From:
Sent: 05 October 2025 13:28
To: DC Admin
Cc:
Subject: Objection to planning application 2020/60/92350/E Land south of, Heybeck Lane, Chidswell, Shaw Cross, Dewsbury.

To the planning officer handling application reference 2020/60/92350/E,

Off Site BNG Area Plan

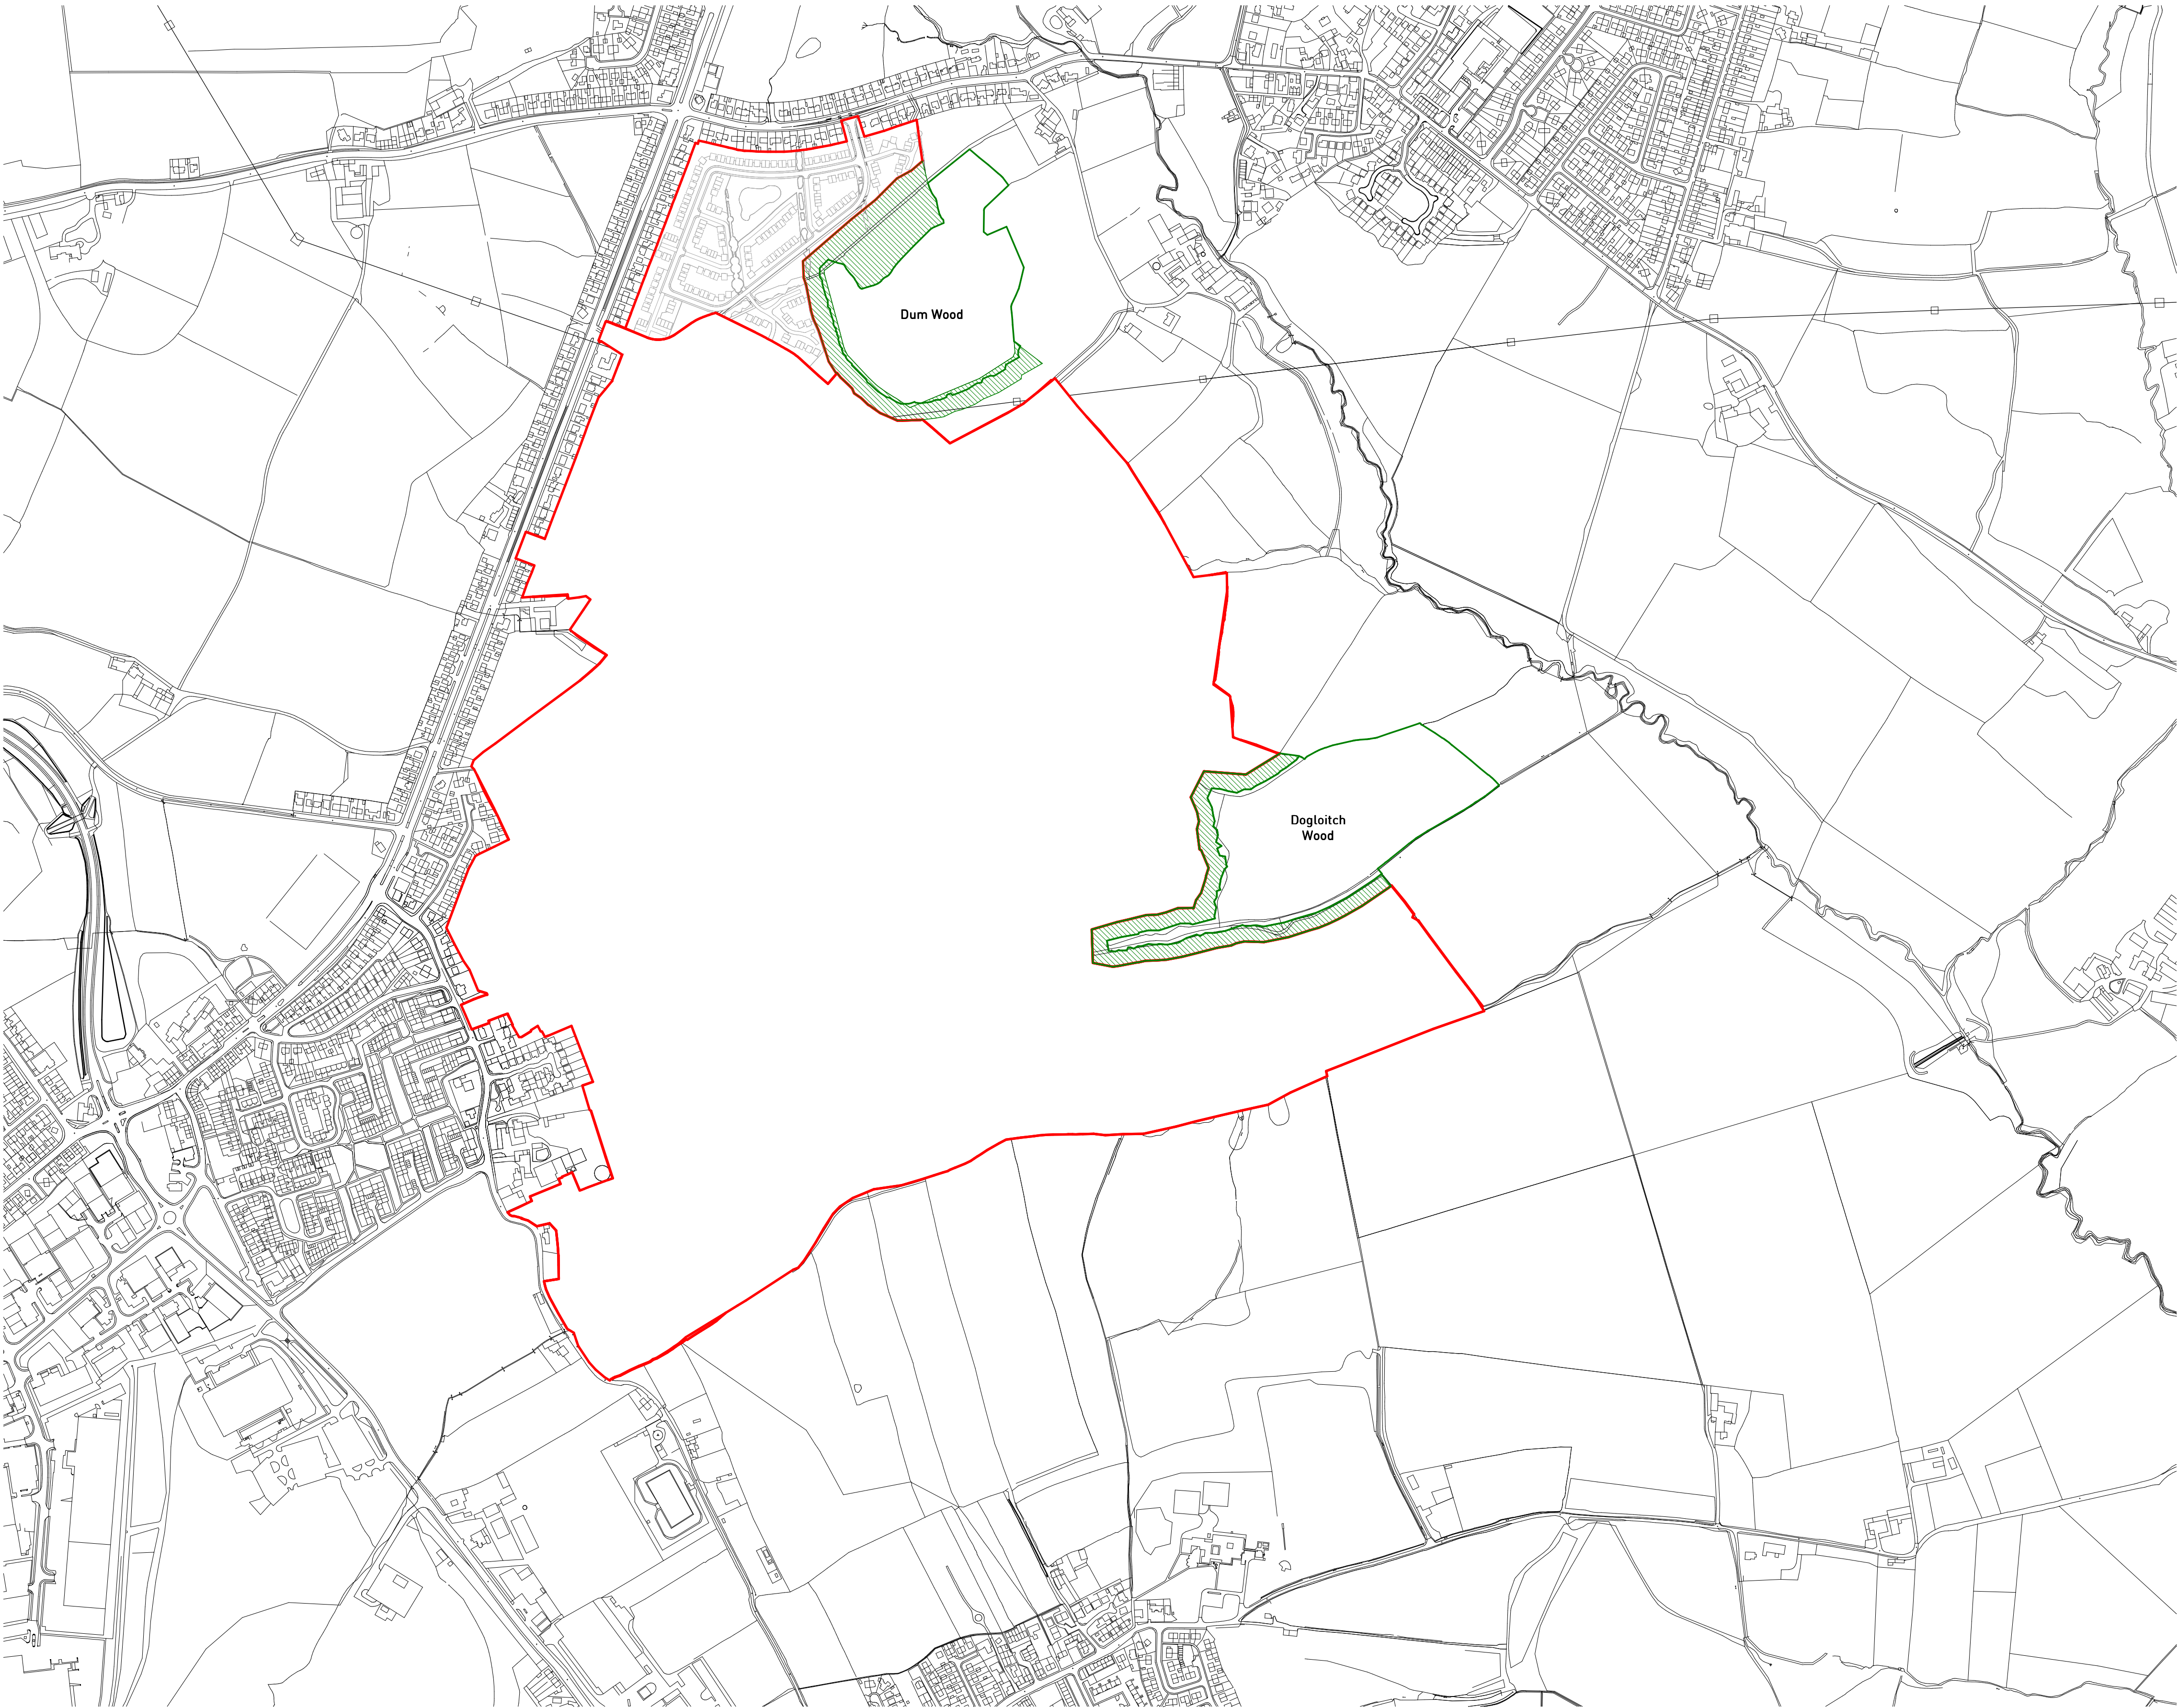
The *consolidated Section 106 agreement* introduces new and material considerations that were not before the SPC in 2022. Specifically, that the 10% Biodiversity Net Gain (BNG) could be delivered *off-site* within **Dum Wood** and **Dogloitch Wood**, both ancient woodlands.

Using existing ancient woodland as "offset land" risks not increasing biodiversity, and instead damaging delicate ecosystems. This proposal appears to represent a superficial attempt to appear compliant. The ecological impact of this proposal has not been properly assessed and requires full scrutiny by elected members.
